Our Case Number: ACP-323860-25

An
Coimisiún
Pleanála

Re: 10 year planning permission for a 220kV AIS/ 220kV GIS substation OR a 110kV electricity substation, associated 220kV or 110kV underground grid connection and ancillary works located in the townlands of Ballyloo, Knockbower, Linkardstown, Kilballyhue, Graiguenspiddoge, Castletown, Moyle Big, Leagh or Ballybeg, Kellistown West & Kellistown East, County Carlow.

Please be advised that the Commission, in accordance with section 182A(5)(a) of the Planning and Development Act 2000, as amended, hereby requires you to furnish the following further information in relation to the effects on the environment of the proposed development:

Project
Ballyloo Substation & Grid Connection
Location
Ballyloo, Co. Carlow
Title
Dry Deck Cable Bridge Crossing
Drawing Number
BYLOO-DR-047
Scale
1:50 @ A3 and 1:20 @ A3
Ballyloo Solar Farm Limited Commercial House, Millbank Business Park, Lucan, Dublin

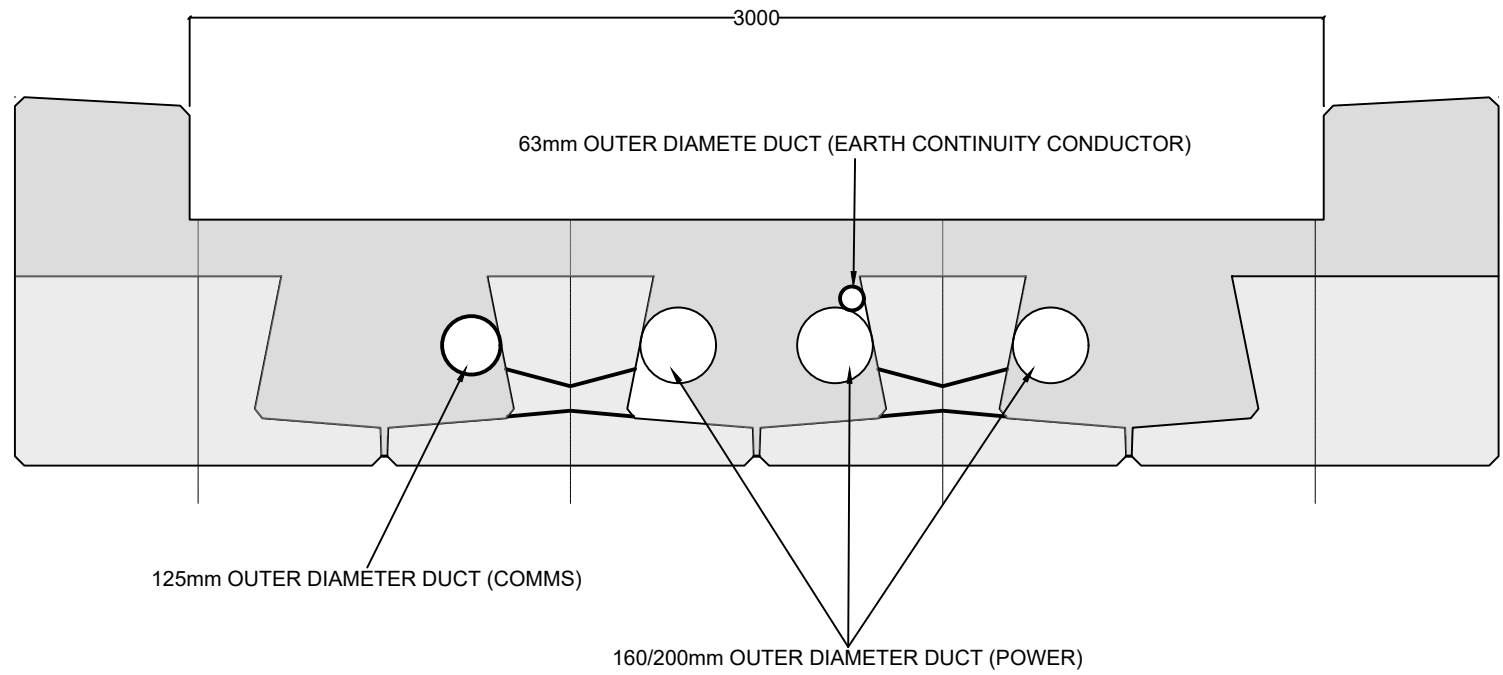
- (i) While reference has been made in h) above to a dry deck bridge, and a drawing has been provided of a dry deck bridge at the proposed entrance to the proposed substation site, it is also noted that Figure 5.4 in the Site Access Report, and Appendix A to the Site Access Report, both which demonstrate the Swept Path Analysis of Entrance 1, includes a note that states 'New Roadside drainage to be carried in new 450mm Ø (diameter) concrete pipes surrounded in concrete during both the construction and operational phases'. In addition, sections 8.3 and 9.6

of the Site Access Report also refer to the installation of 450mm diameter pipes parallel to the site entrance and the use of soakpits. Please clarify these statements in the context of item h) above and in the context that other submitted documents state that no instream works are to be carried out as part of the proposed development, which would not be correct, if it is intended to install roadside drainage pipes in an existing roadside drainage ditch.
